From: Anita Gardner
Sent: 04 December 2018 17:38
To: 'Kevin Conlon'
Subject: FW: FG/171/18/DOC - Peugeot Garage Premises, Littlehampton Road,

Environmental Health: Application for discharge of conditions. Further information required.

Honda Worthing 11-07-18 EXT REV 0

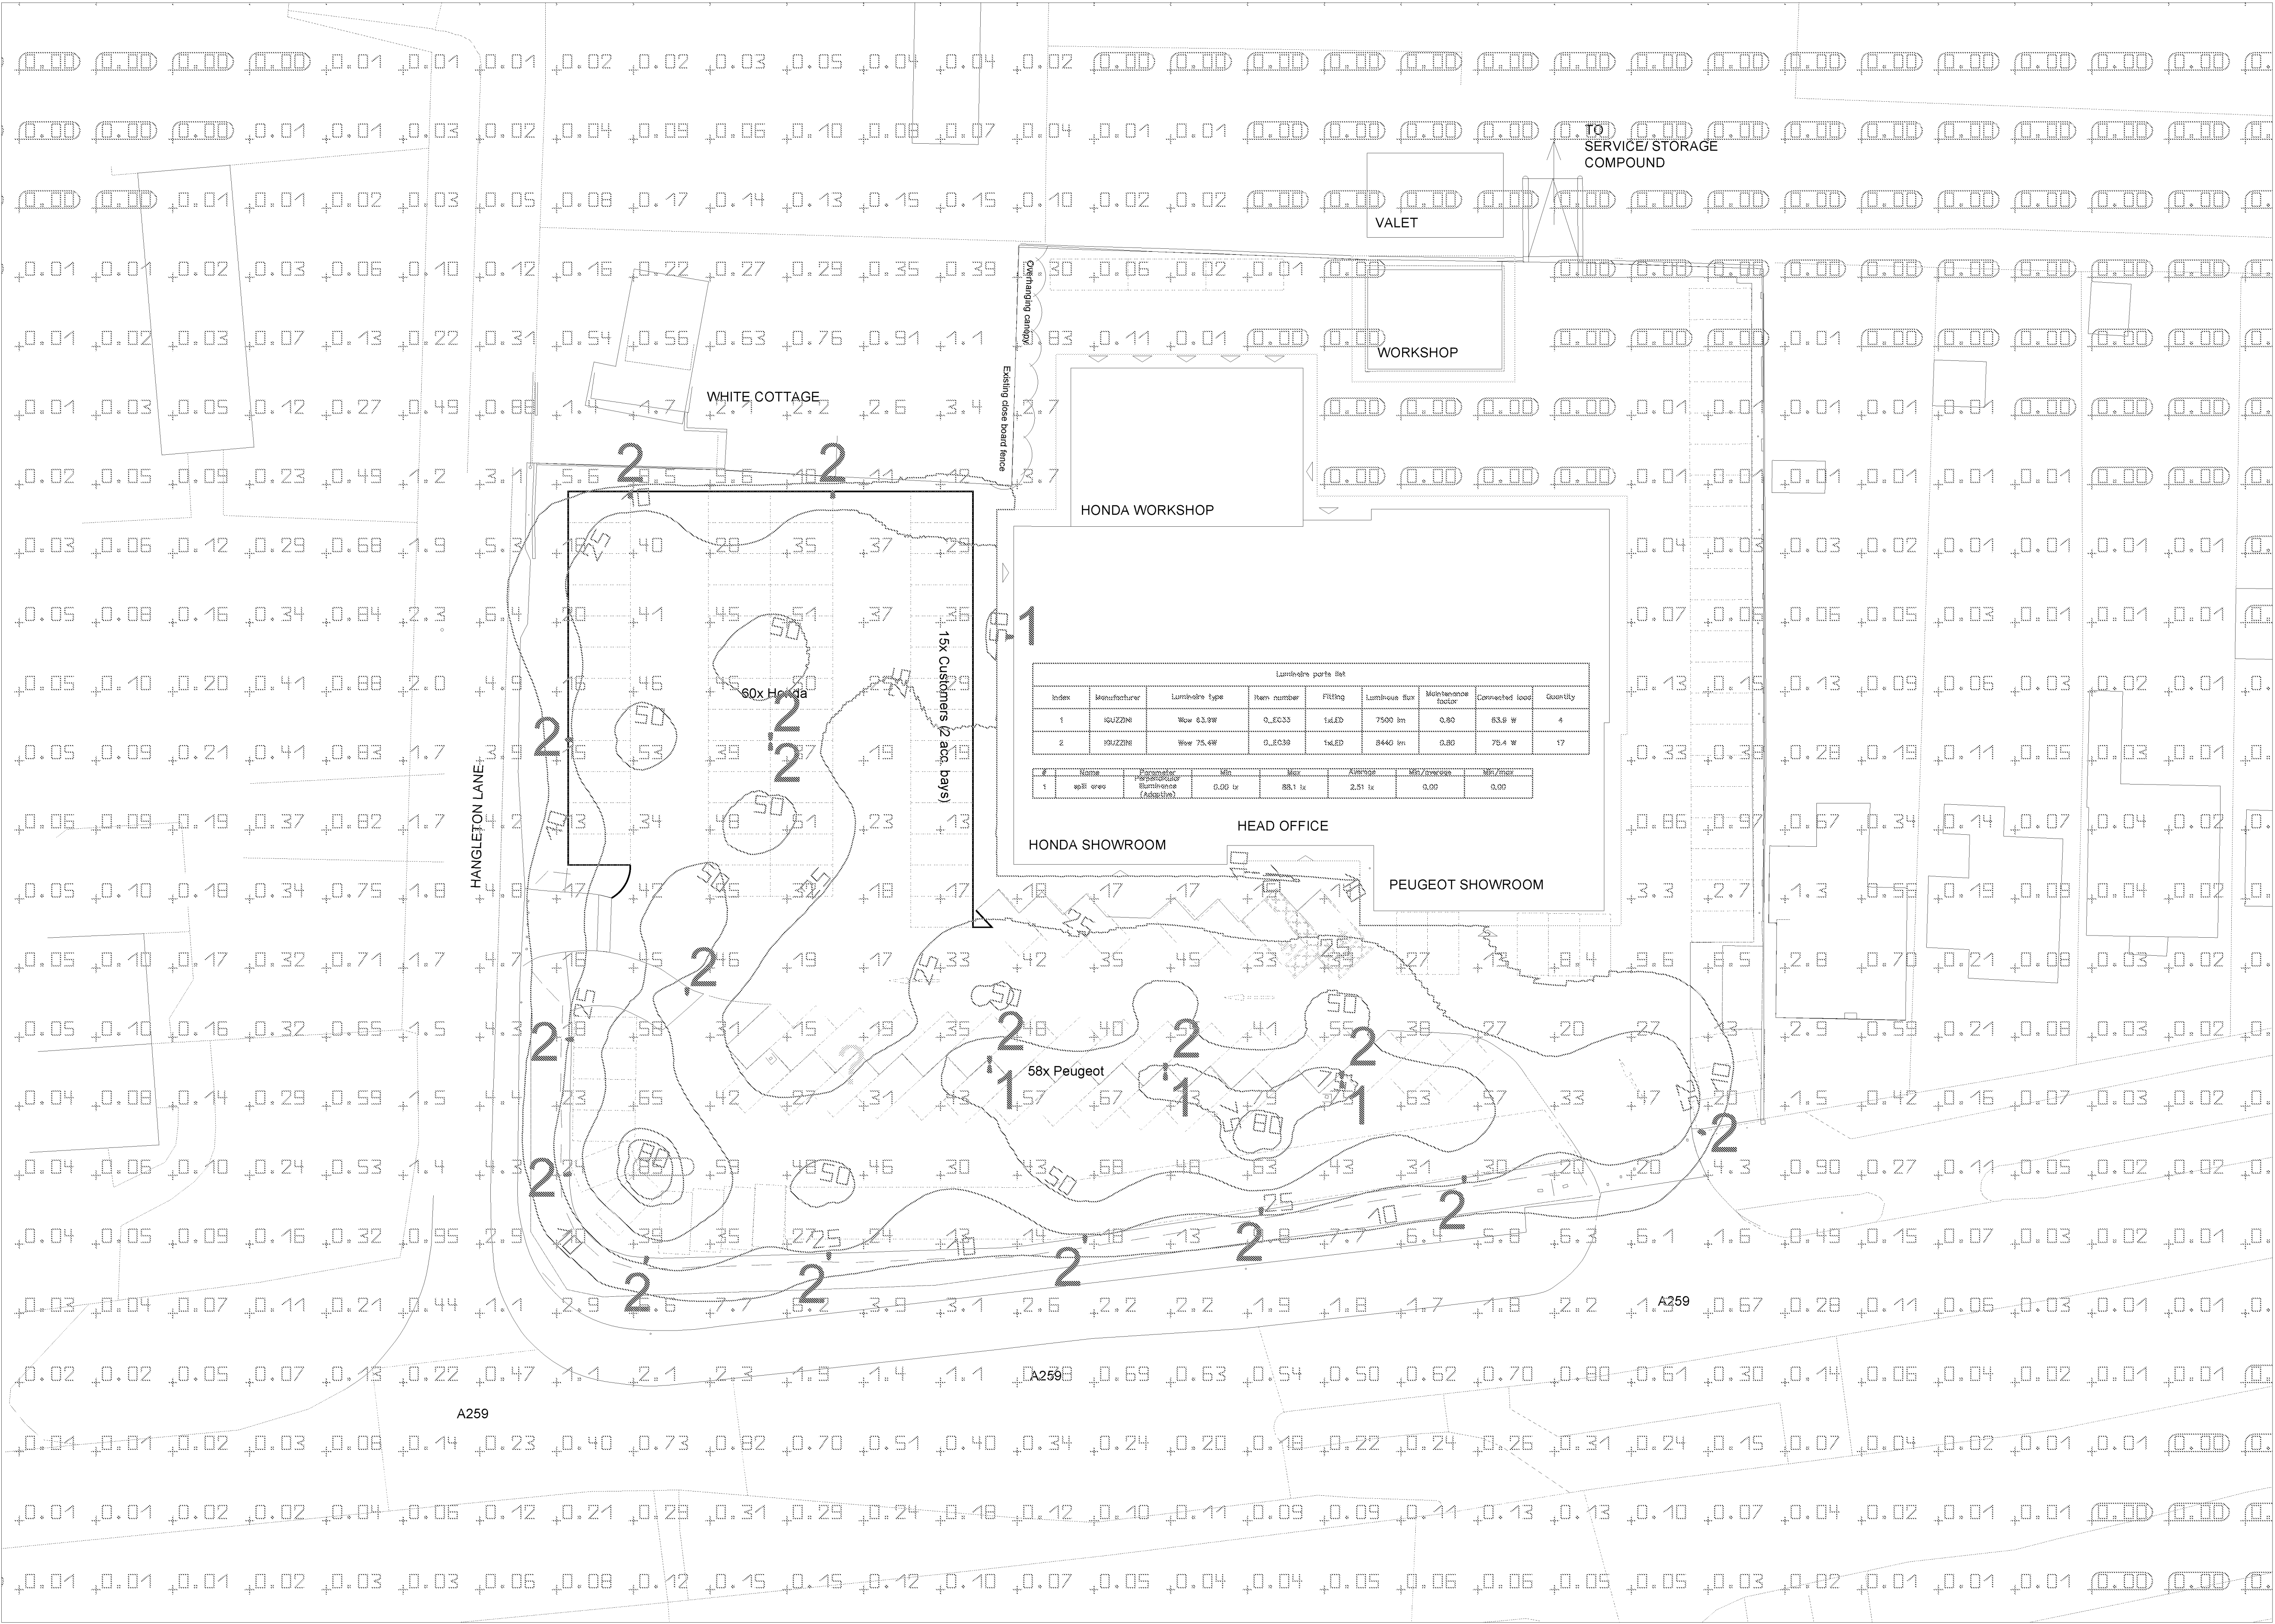
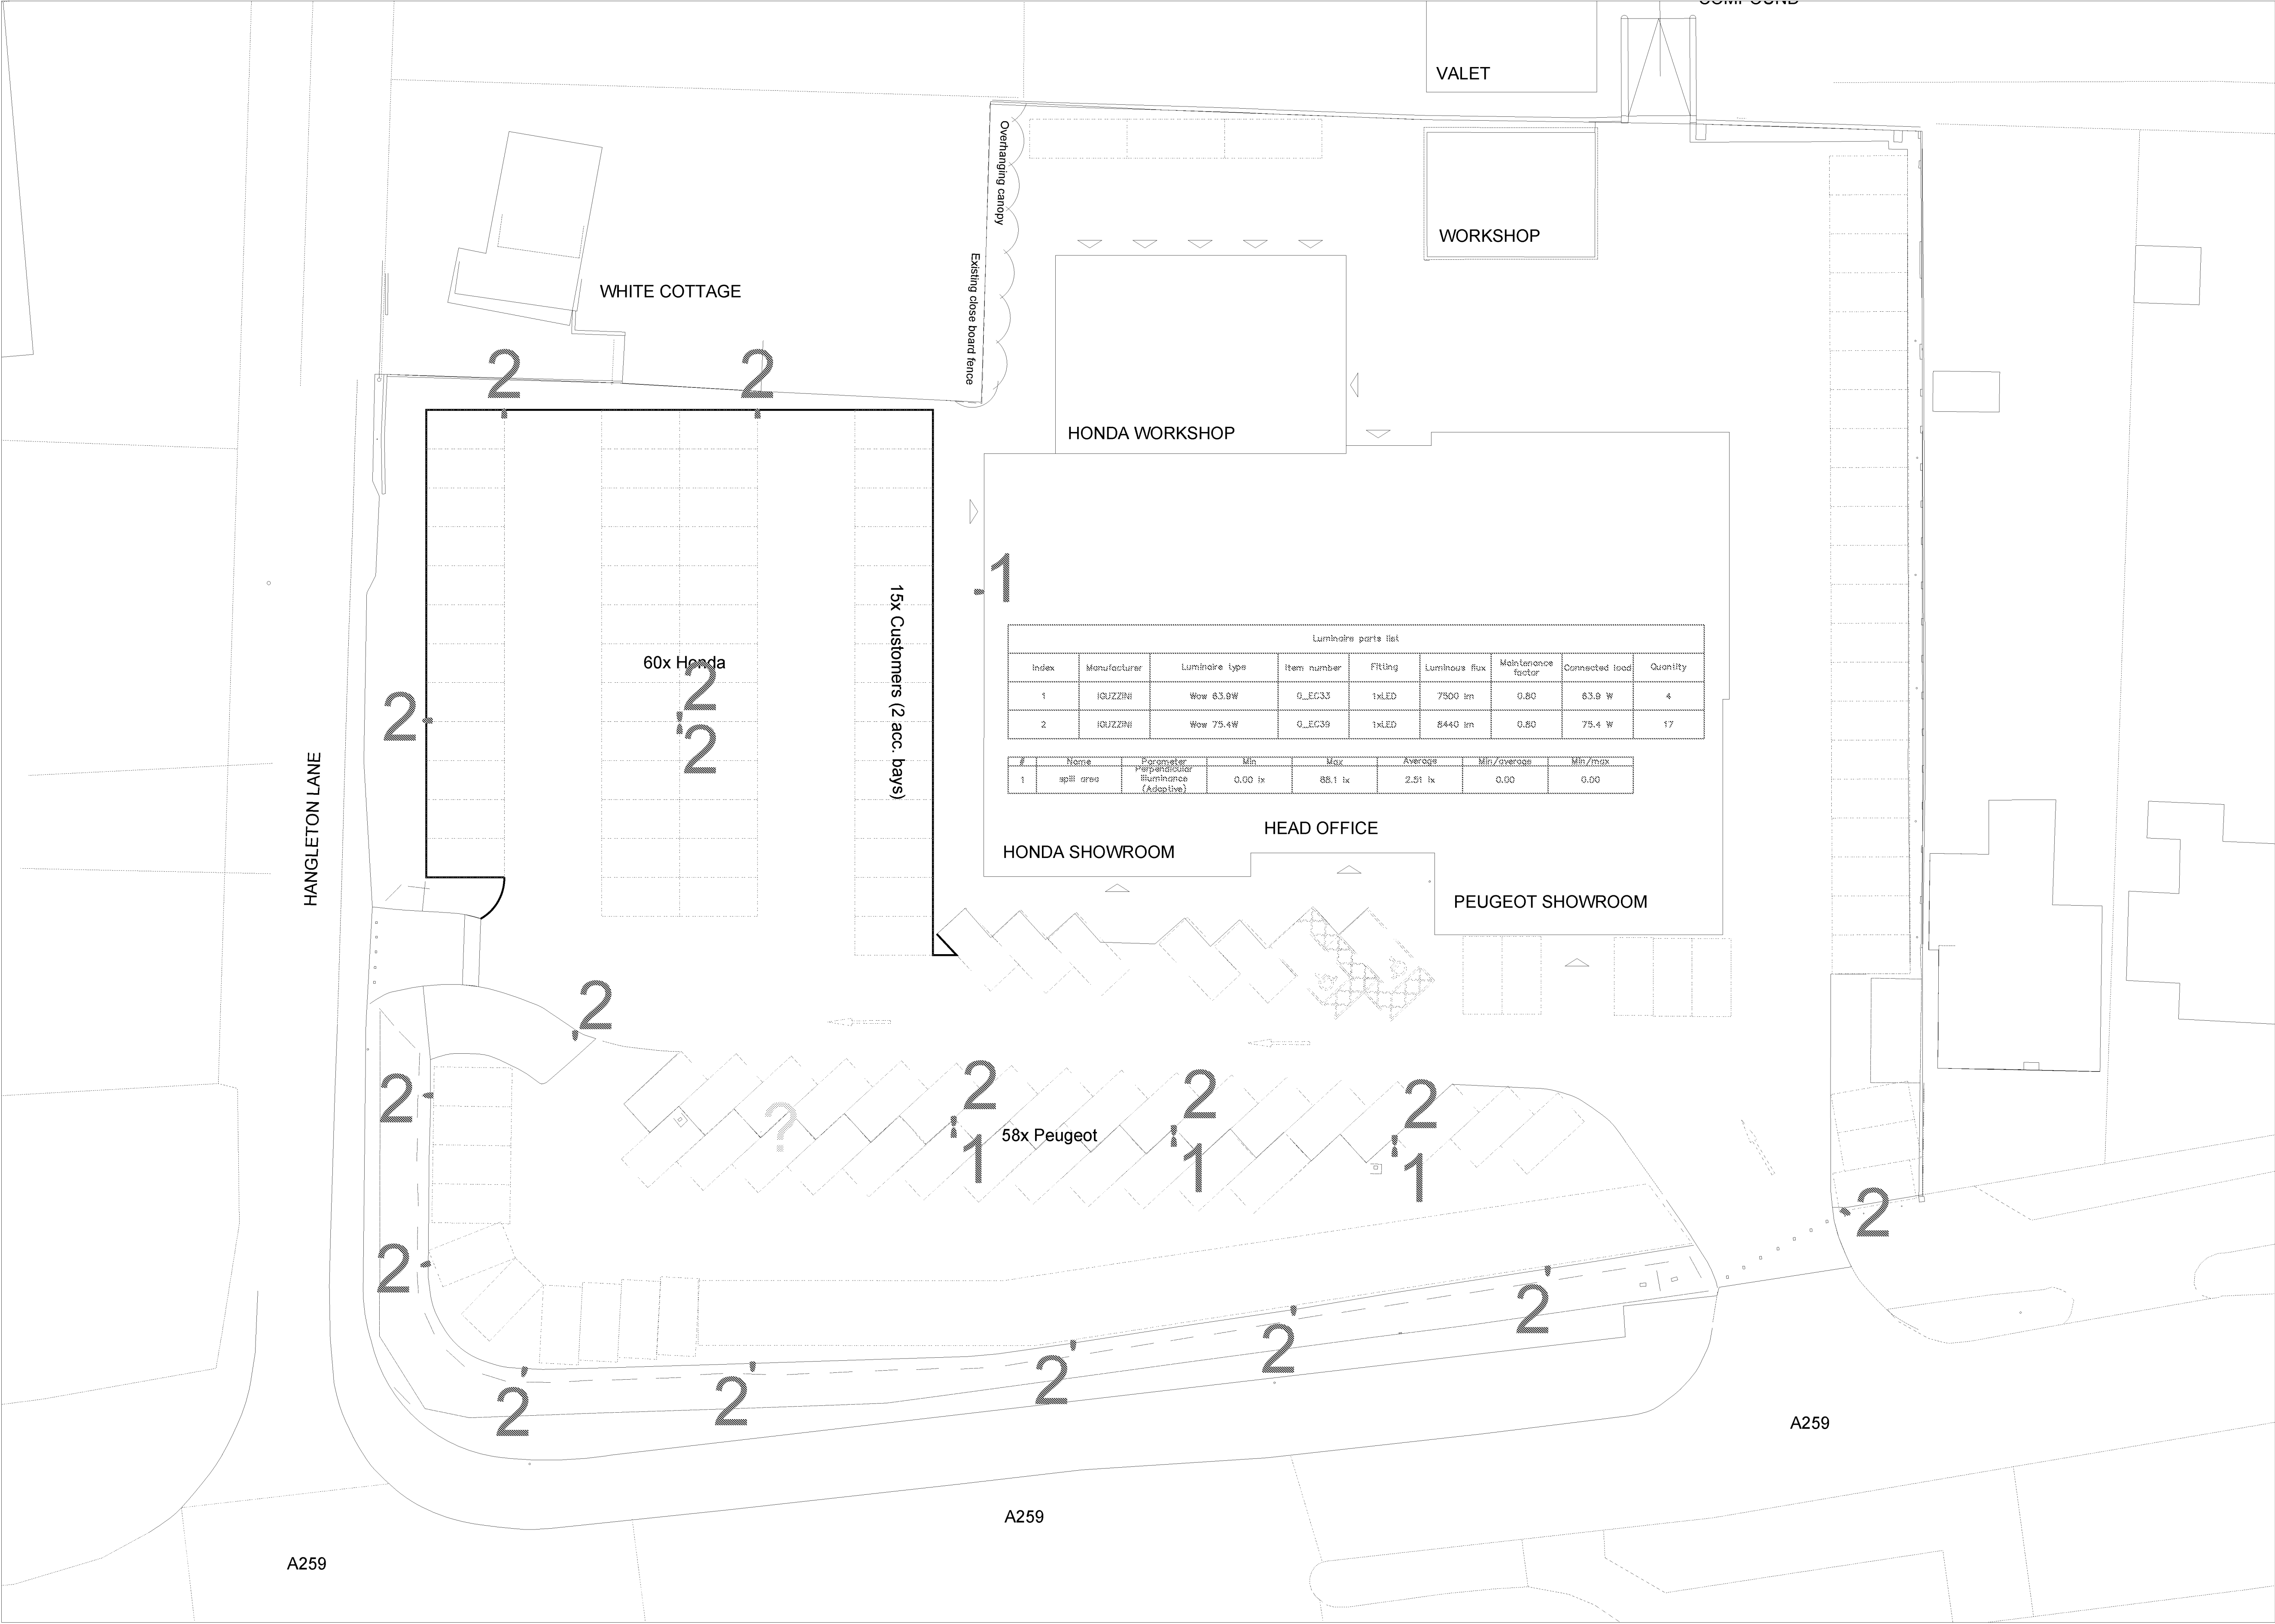
Lighting Plan: Lower level lighting, specified as 'Type 1' to be provided to areas proximal to sensitive receptors and to the north of the site in order to prevent detriment to the amenity of these properties and South Downs National Park.
